YORKSHIRE GARDENS TRUST

26th October 2021

2021/93674 Partial redevelopment of Greenhead college including demolition and making good, erection of 2 and 4 storey buildings, reconfiguration of parking and access arrangements, reconfiguration of sports provision and other associated external works (Within a Conservation Area), Greenhead College, Greenhead Road, Huddersfield, HD1 4ES

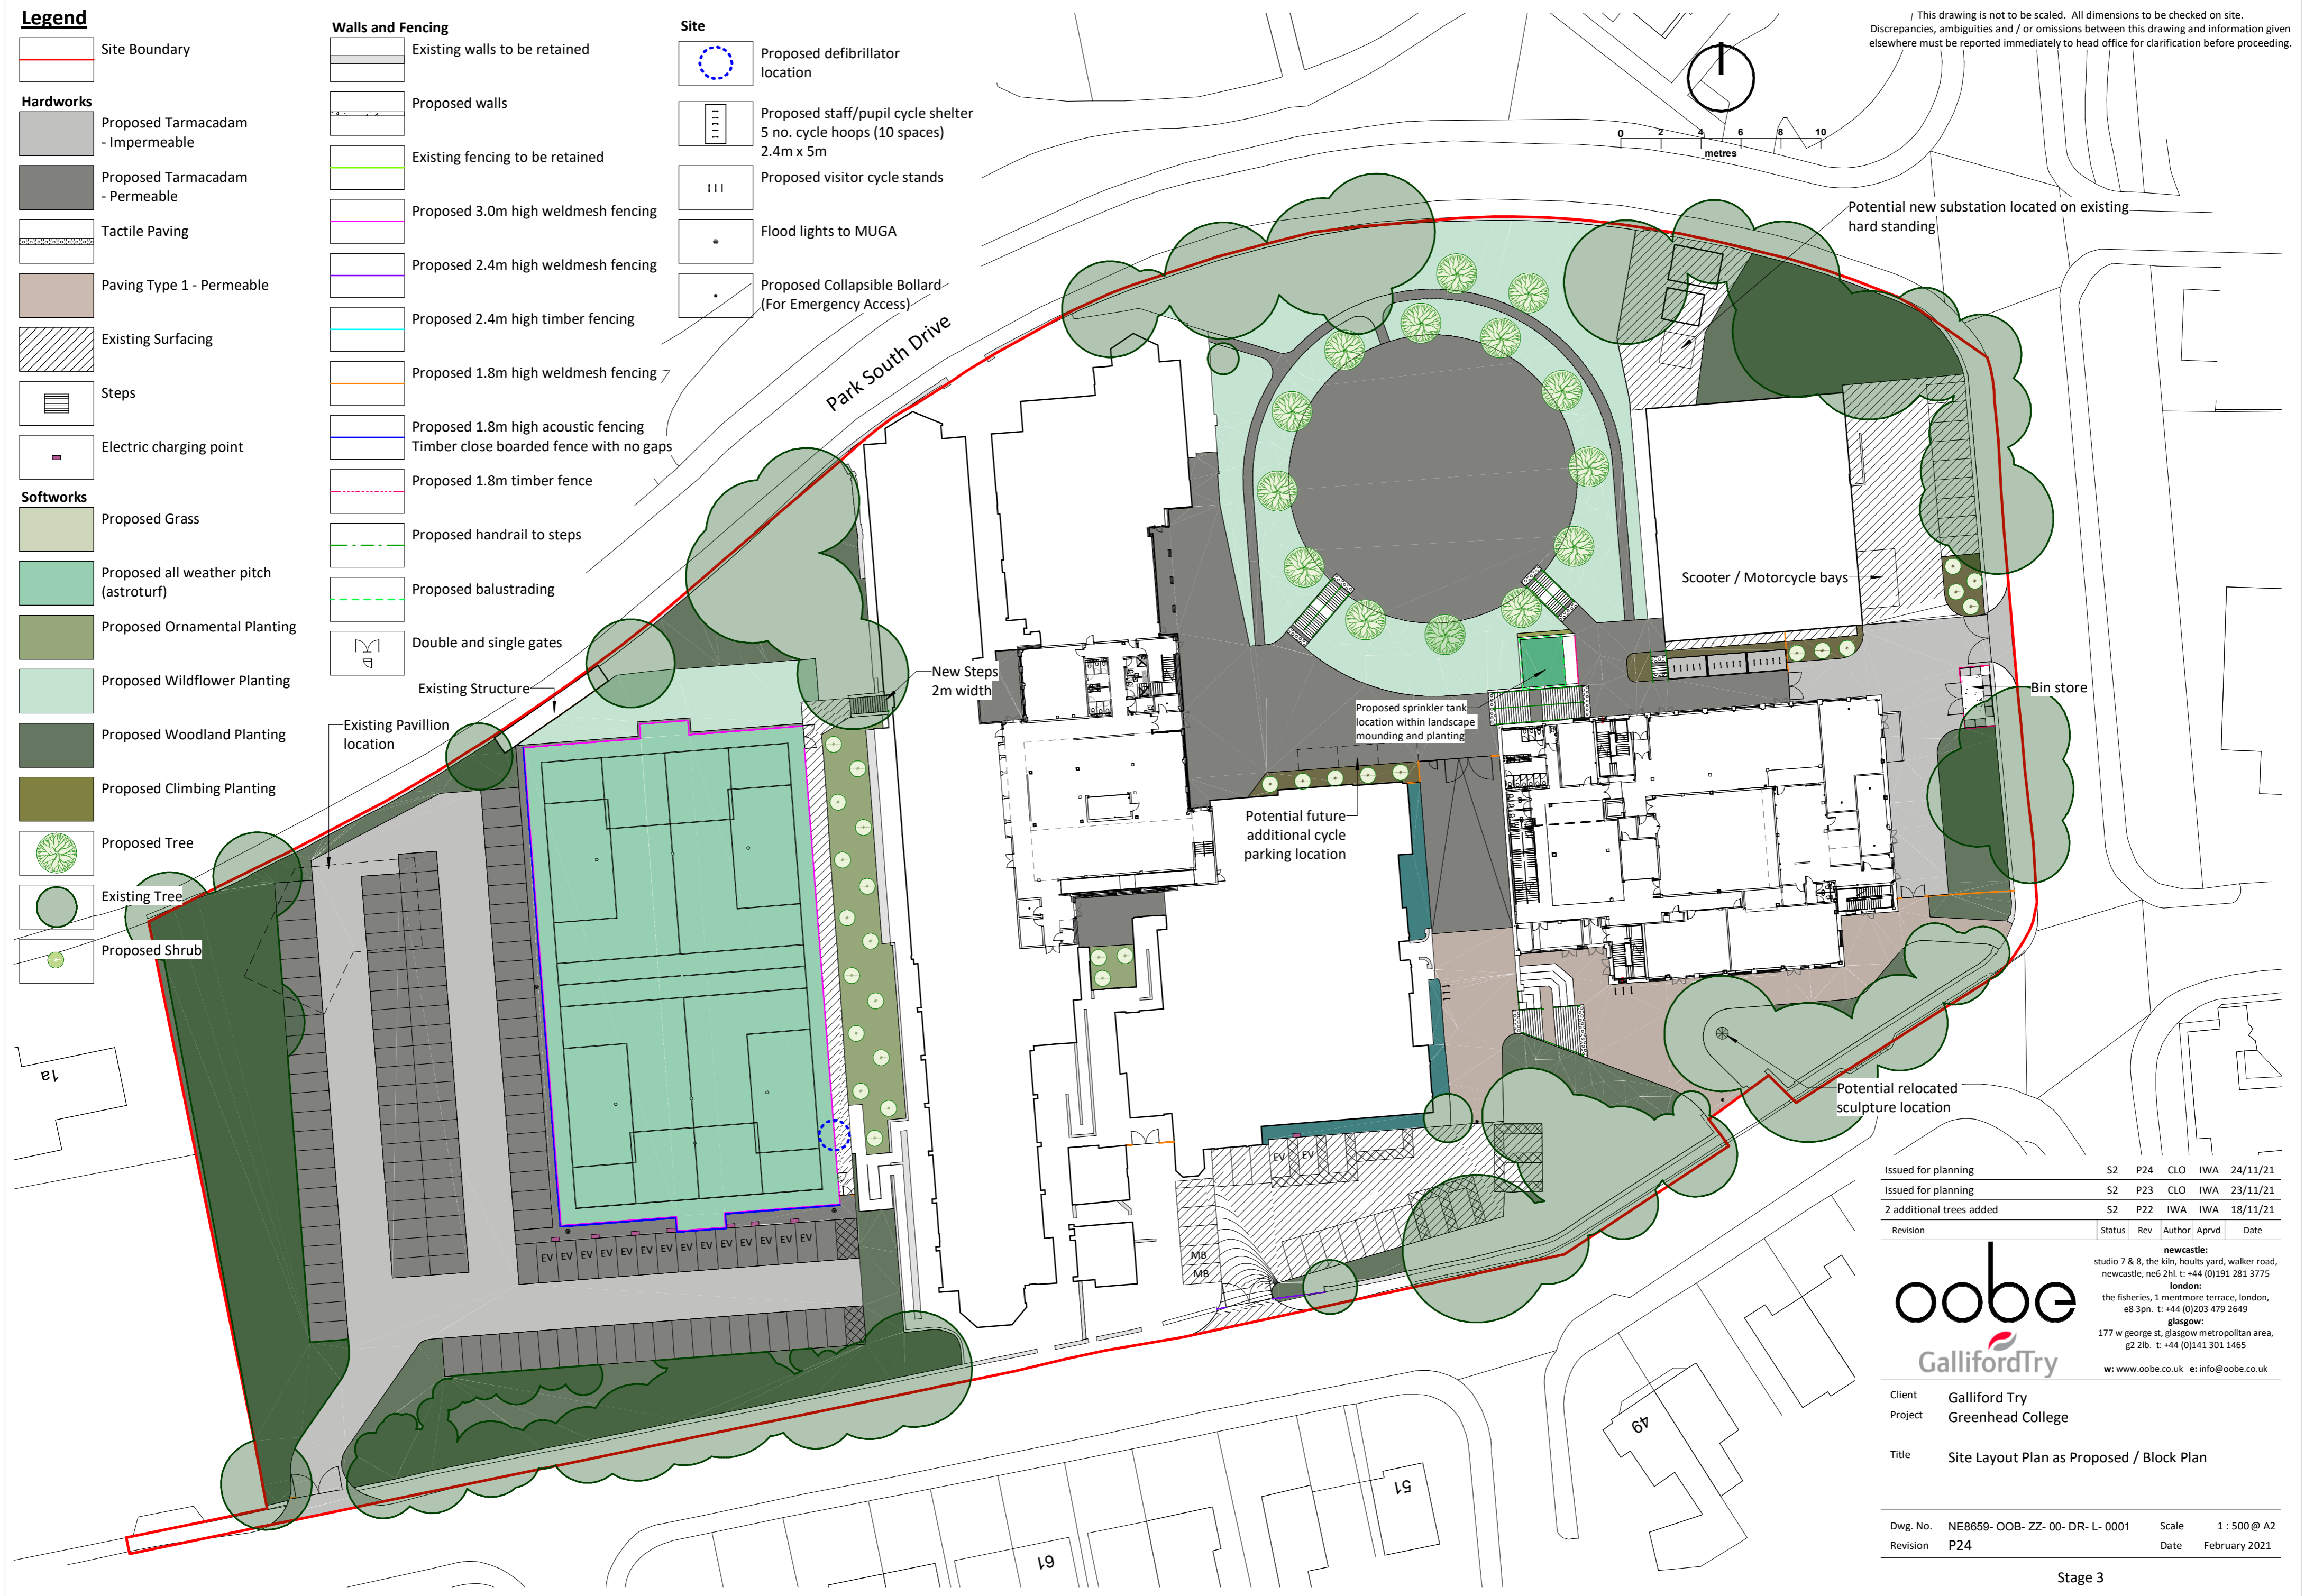
Our point 1: regarding a landscape plan. We are pleased to see the planting strategy plan including retention of existing trees, proposed ornamental planting, woodland planting, wildflower planting, green roof and new trees round the student hub. Our concern would be with the maintenance of these areas; which although they are commendable, will require a considerable degree of maintenance both for the first three to five years until the areas are established, and then a schedule of monitoring and maintenance thereafter with commensurate funding allocated specifically for these areas. This is particularly so for all the herbaceous planting ie ornamental planting shade, ornamental planting sun, and woodland herb layer. A flowering lawn can be quite difficult to establish and maintain; eg needing mowing only after flowering (say late July into August depending on flowering species in the mix), to allow seed to fall. It maybe that monitoring and maintenance by students overseen by interested staff could be part of the approach. The green roof, presumably a wildflower biodiverse roof, will be a beneficial addition but some maintenance will be required to keep it in good condition. This includes cutting it back in about July, depending on the season, to reduce

Regarding the impact of the proposed development on Greenhead Park and the Conservation Area, the existing boundary trees are important and we trust that there will be a tree replacement strategy for any that fail.

We are pleased to note the permeable elements of the hard landscaping and support the introduction of permeable and green surfaces as much as possible, and also the retention of vegetation and additional buffer planting.
